Ribble Valley Borough Council
Council Offices
Church Walk,
Clitheroe
Lancashire
BB7 2RA

Phone: 0300 123 6780
Email: [REDACTED]
Your ref: 3/2025/0107
Our ref: 3/2025/0107/HDC/KW
Date: 27 March 2025

Location: Boadicea Park Preston Road Ribchester PR3 3XL
Proposal: Retention of two holiday lodges and office building with associated parking, infrastructure and alterations.
Grid Ref: 364726 435655

'Existing' Site Plan and Block Plan Layout

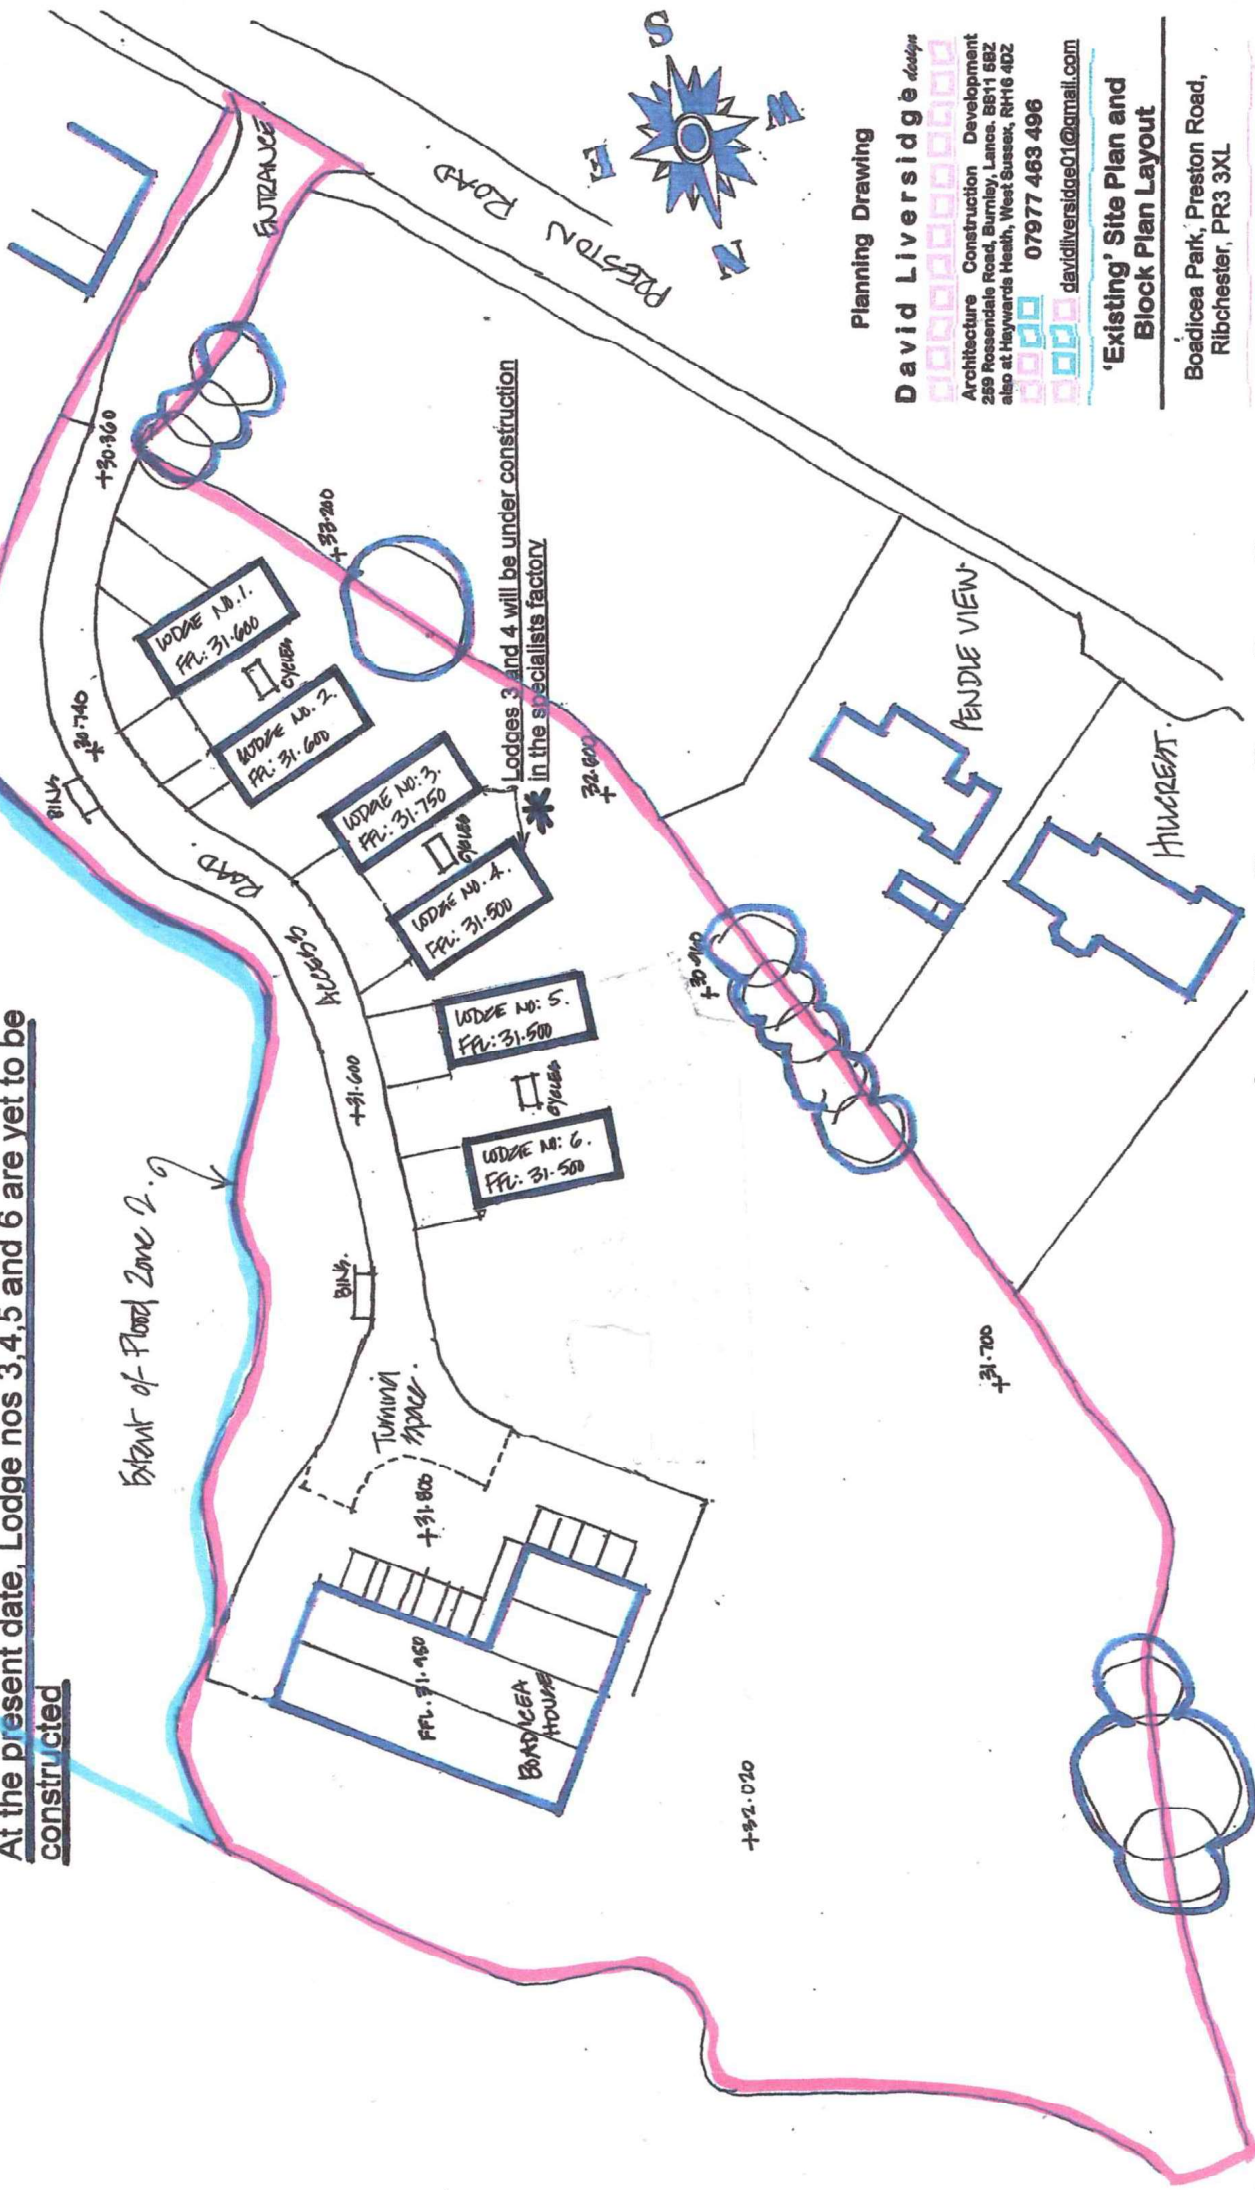
The LHA have reviewed drawing number 25/03/03A and the previously approved site plan, cabins 5 and 6 are to be relocated further north within the site and an office building is included to the East of Boadicea House.

#### Detached Warehouse Quality Control Office

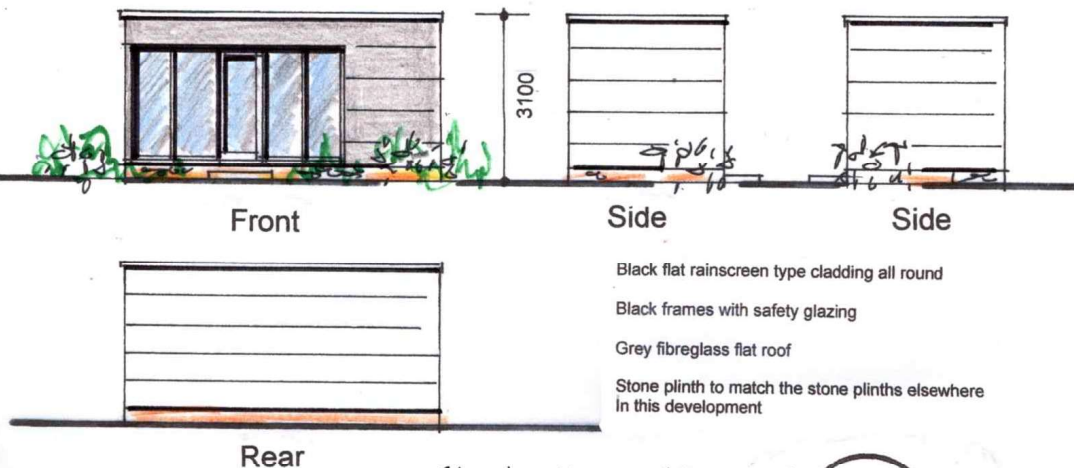
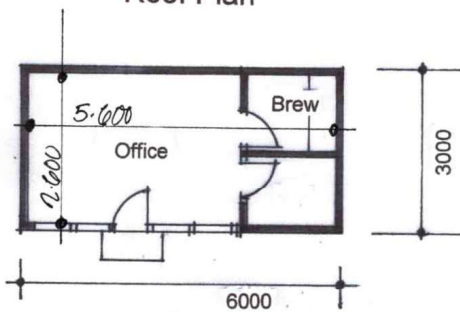
The office building will be placed over an approved loading area however, 10m of hardstanding will still be retained in front of the building, which could cater for service vehicles and does not impose on the turn provisions as such the LHA does not raise any concerns.
